Shivesh Singh - Online Submission from Natalie Miller (object)

Submission for Job: #3779 MP10_0016 - Project Application for Seniors Housing and Care Facility

Site: #2200 Scottish Hospital, 2 Cooper St, Paddington

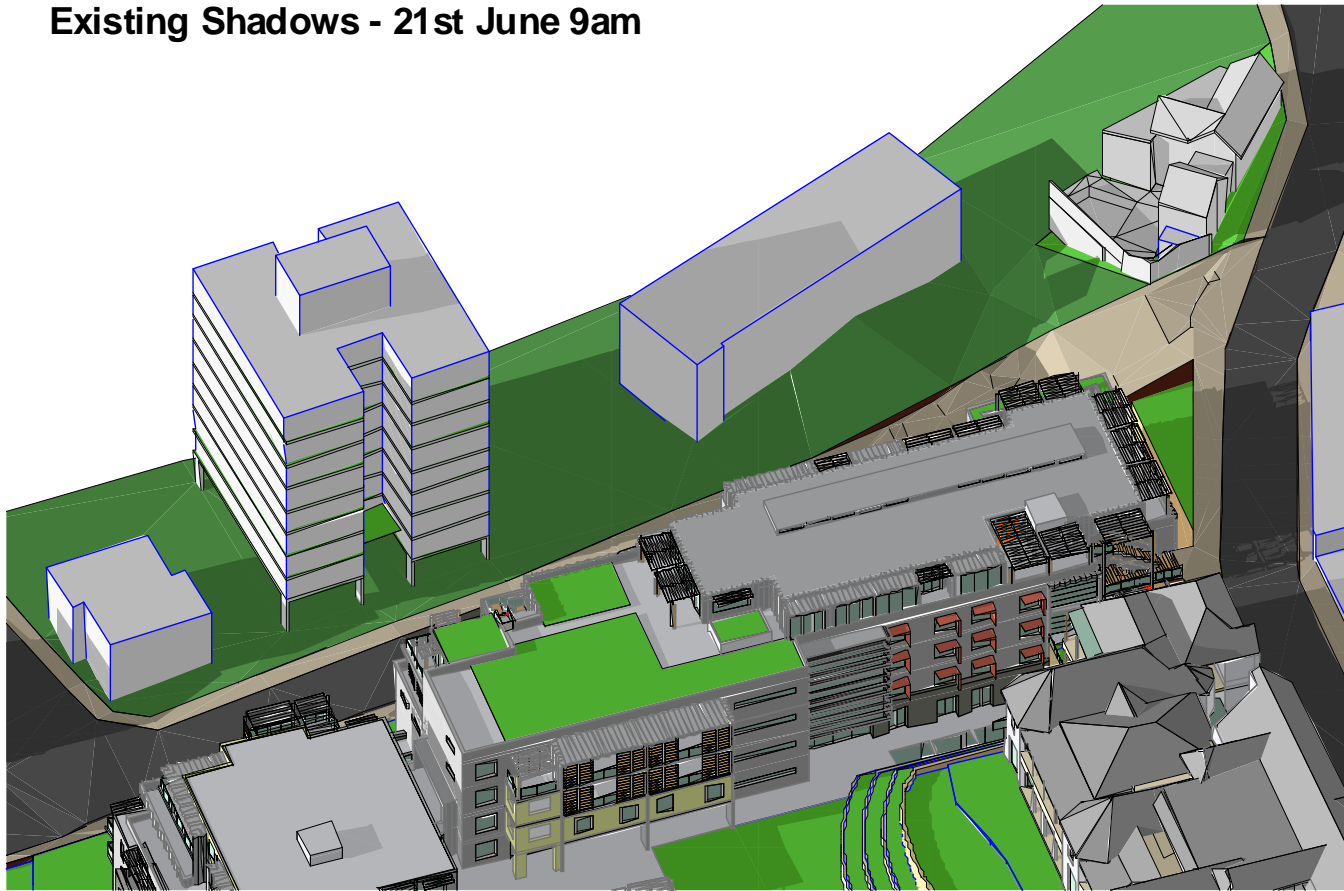
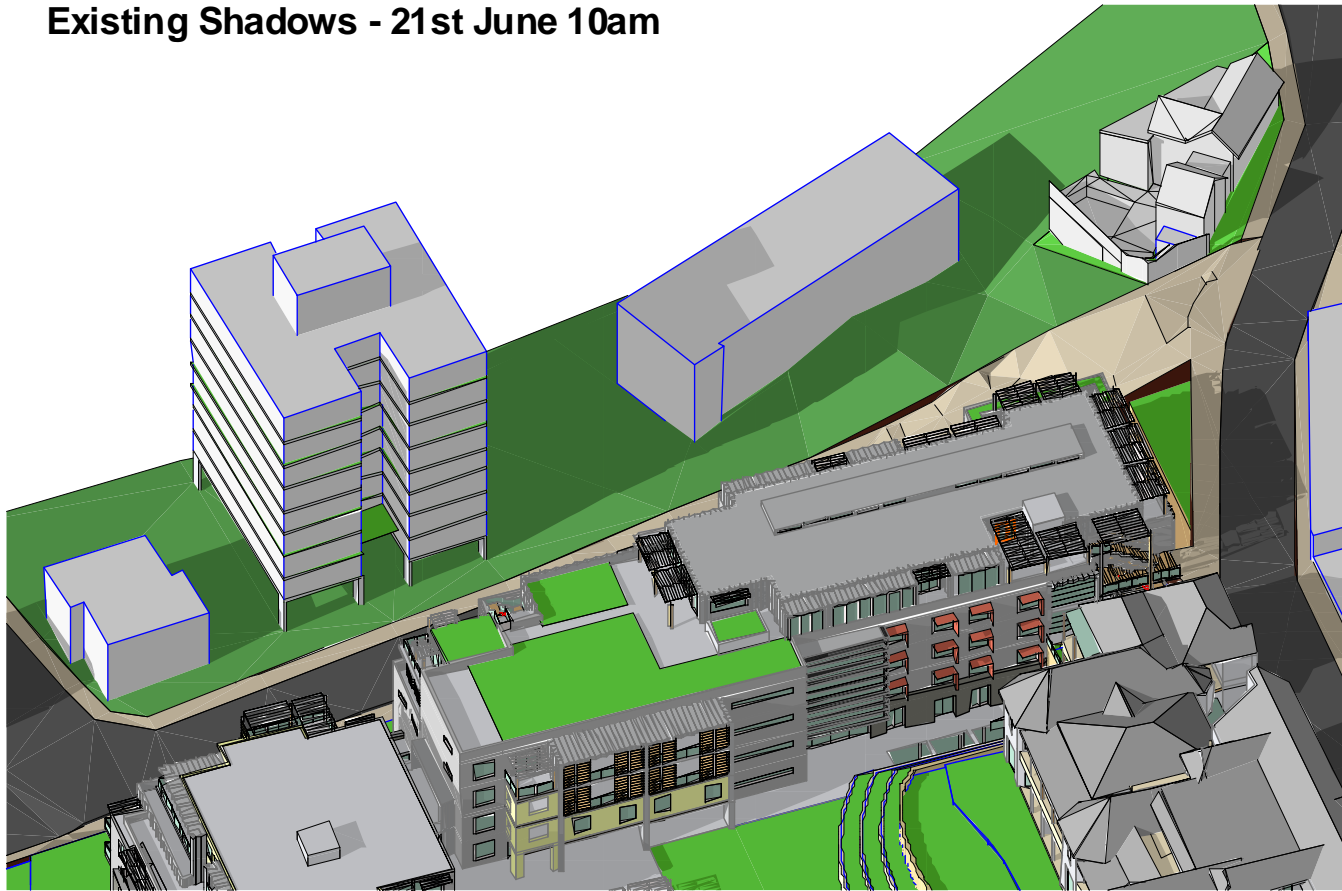
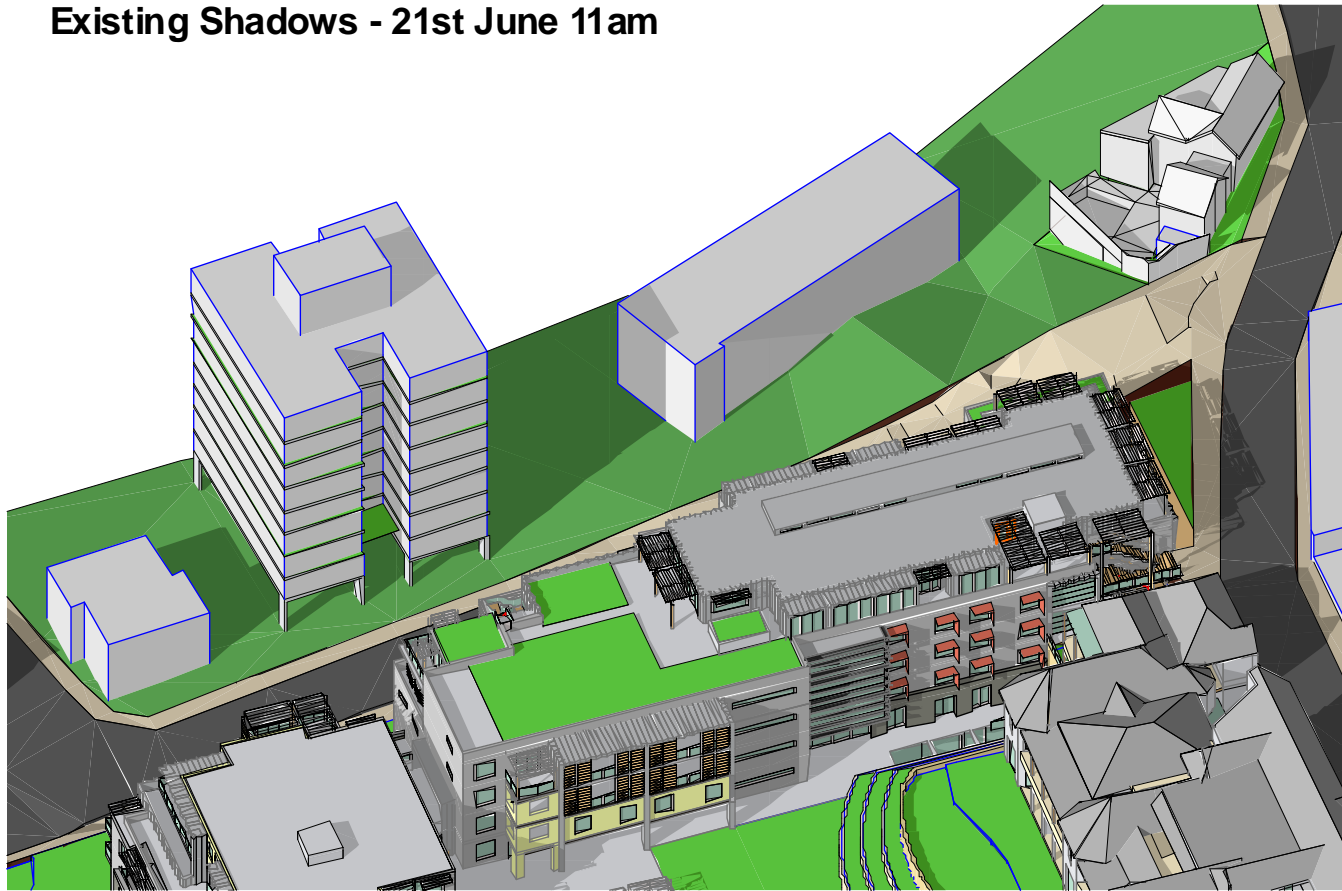
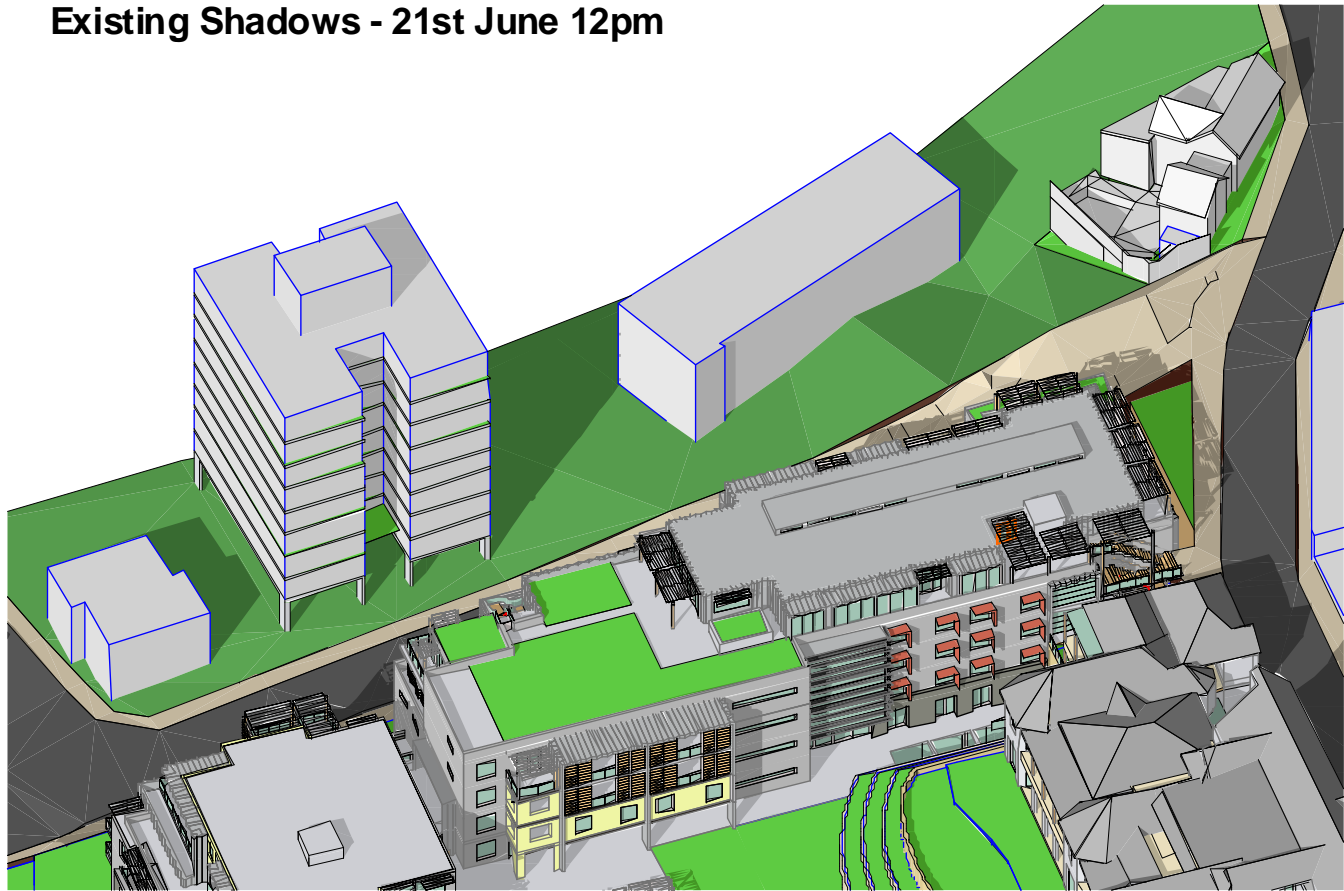
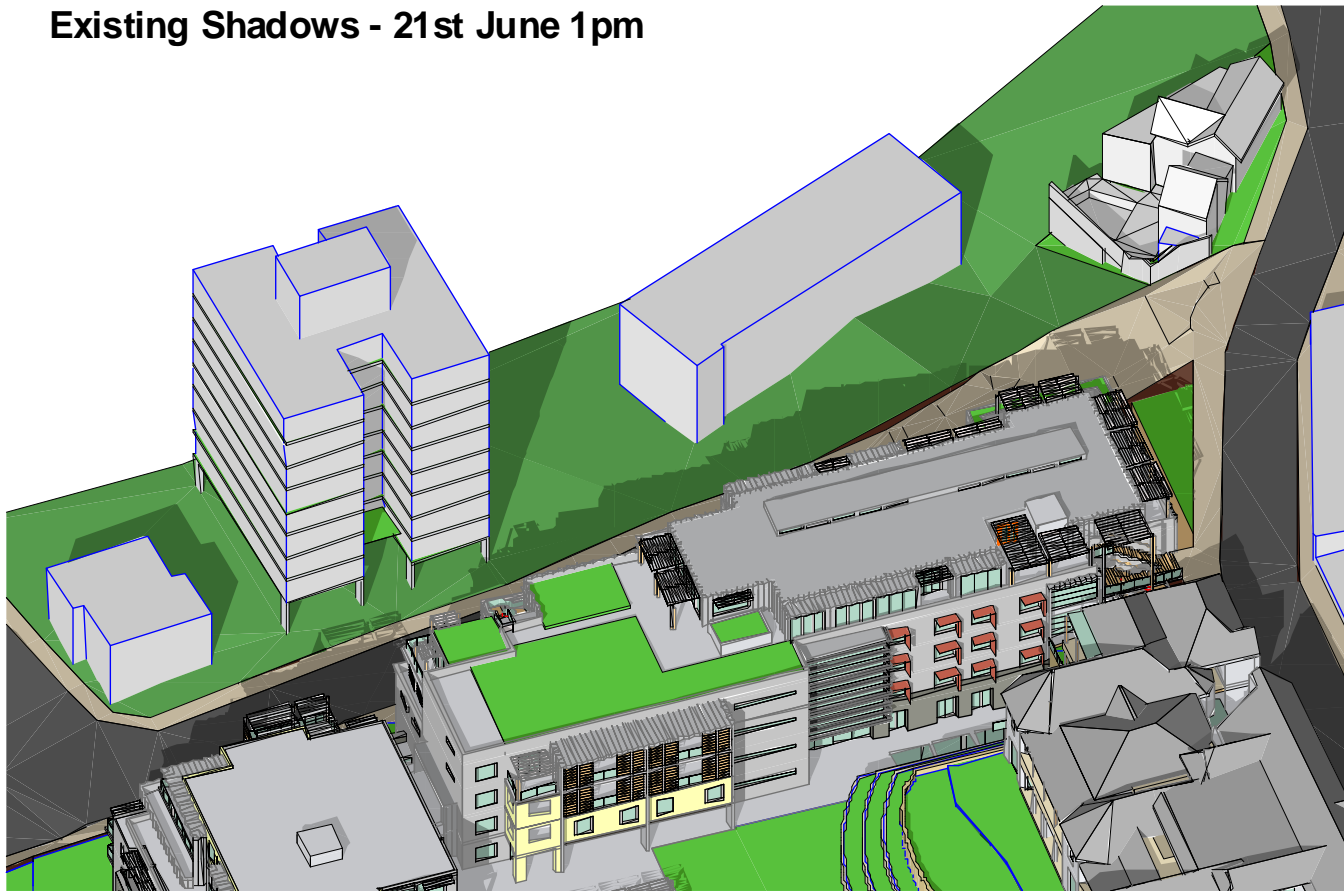
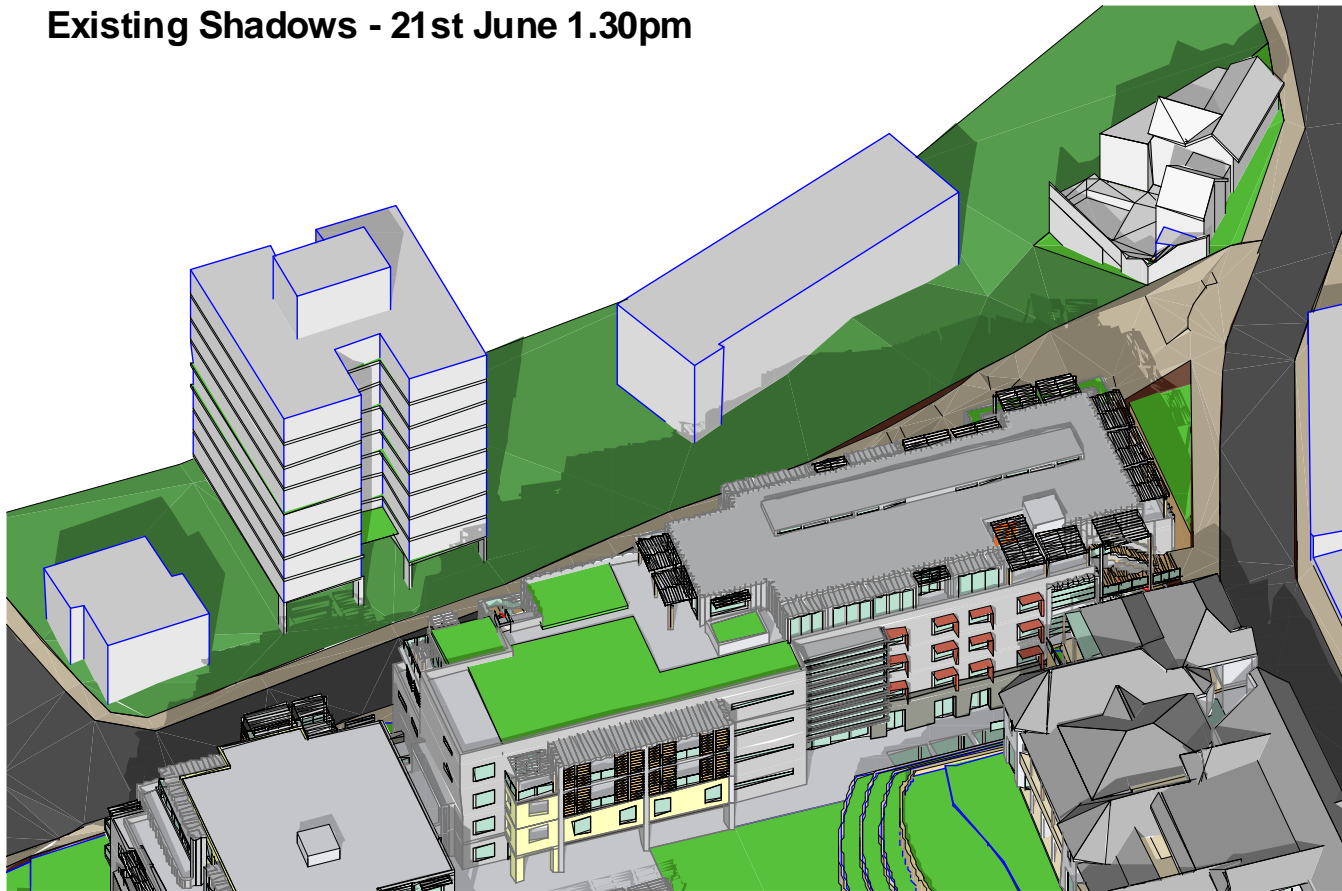
The shadow diagrams (which we are not drawn on) indicate additional overshadowing in winter onto our backyard.
